Your Ref: OWPC20591
Our Ref: LU/269/18/HH
Please ask for:
Stuart Corbey

14th November 2018

Vehicular access & hardstanding to front garden.
110 Southfields Road Littlehampton

REF LU/269/18/HH

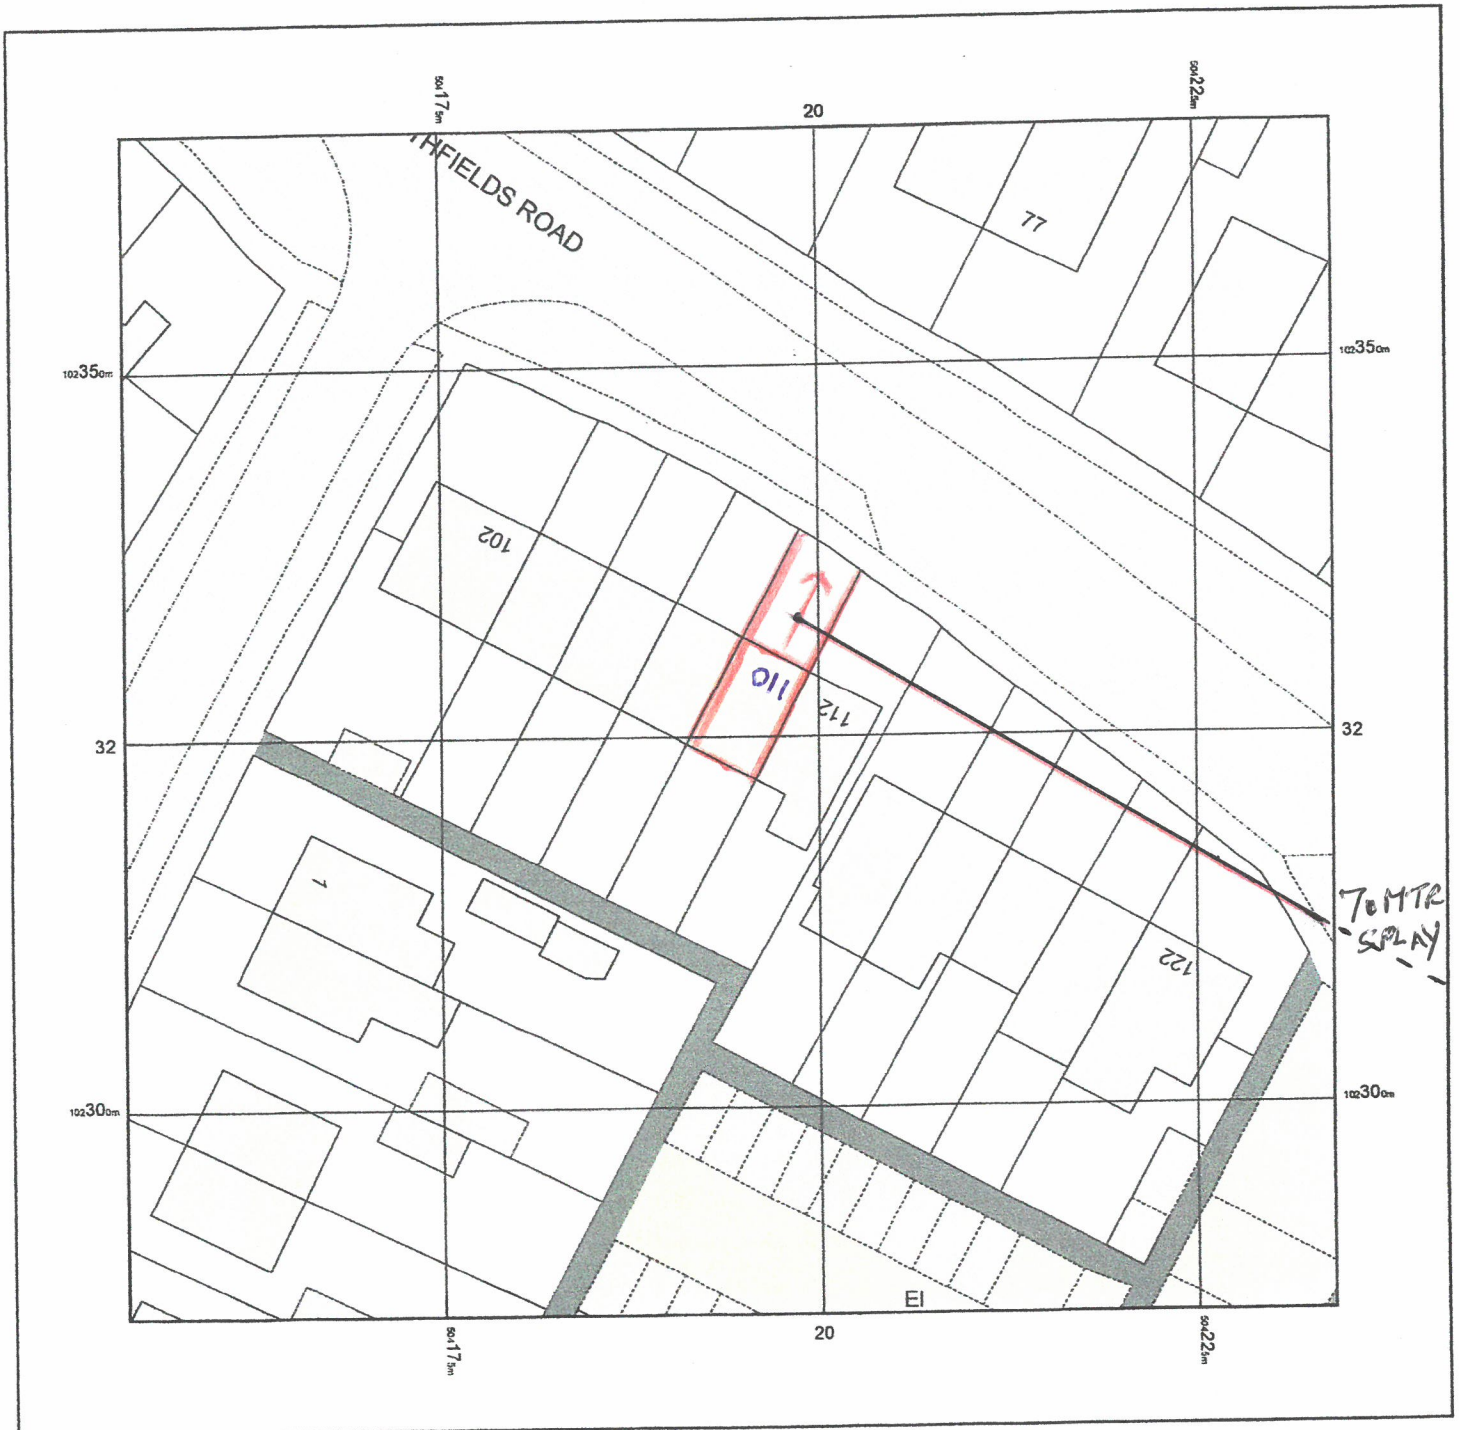
The Town Council's Planning and Transportation Committee considered this matter at its meeting held on Monday 12th November and object to the application. It was observed that the proposals impinged upon a layby on the highway and would result in the loss of public parking provision. The plans also conflicted with Section 3 of the County Council's Vehicle Crossing Guidance which states that they "do not permit the construction of vehicle accesses into parking laybys or dedicated parking areas". In the absence of any comments from West Sussex Highways, the Committee therefore objected to the application on the grounds that the proposals adversely affected highway safety and the convenience of road users.
